Rezoning Transportation Analysis

Petition Number: 2023-046

Date	Description
08-25-23	First Review (NK)
09-20-23	Second Review (NK)
11-22-23	Third Review (TP)
12-20-23	Fourth Review (NK)
1-24-24	Fifth Review (NK)

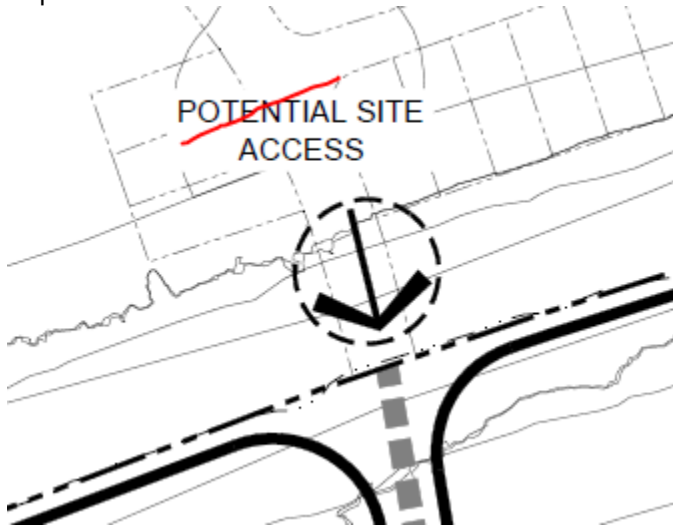
6. ~~Revise site plan to commit to removing the word potential from the access points as these are required~~ ~~connections.~~

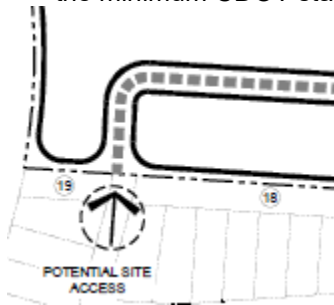
7. **Outstanding Issue 8/24/23:** Remove this intersection, and ensure all future horizontal curves meet the minimum CDOT standard of 150' radius.

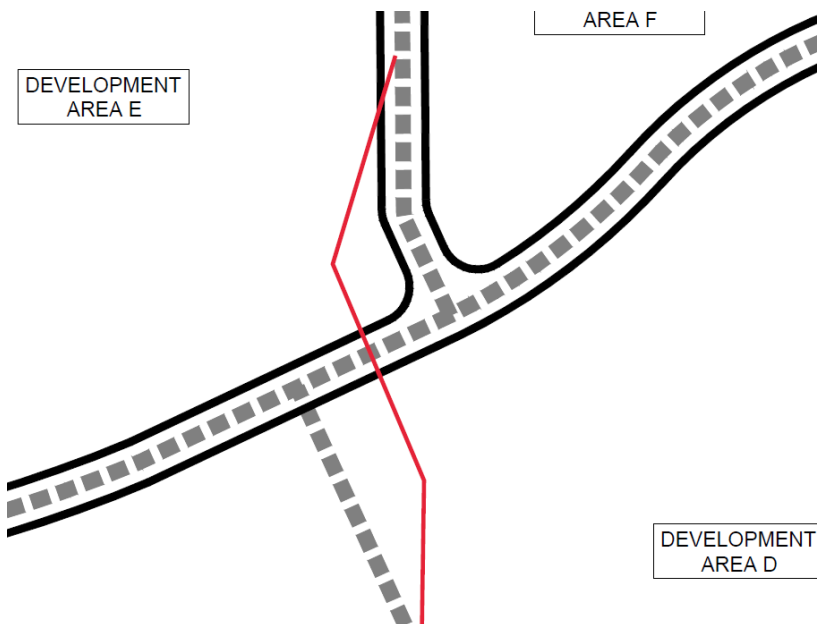
8. **Outstanding Issue 8/24/23:** Align internal public roads to remove offset intersections.

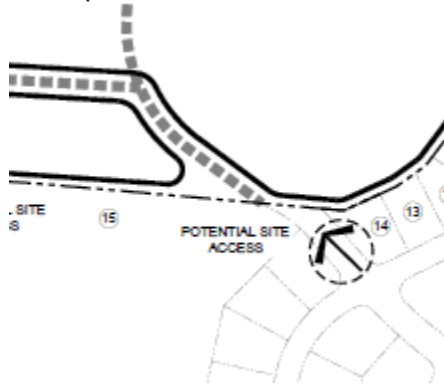
9. ~~Outstanding Issue 8/24/23:~~ The horizontal curves pictured below need to have a minimum 50' separation to meet minimum CDOT standard.
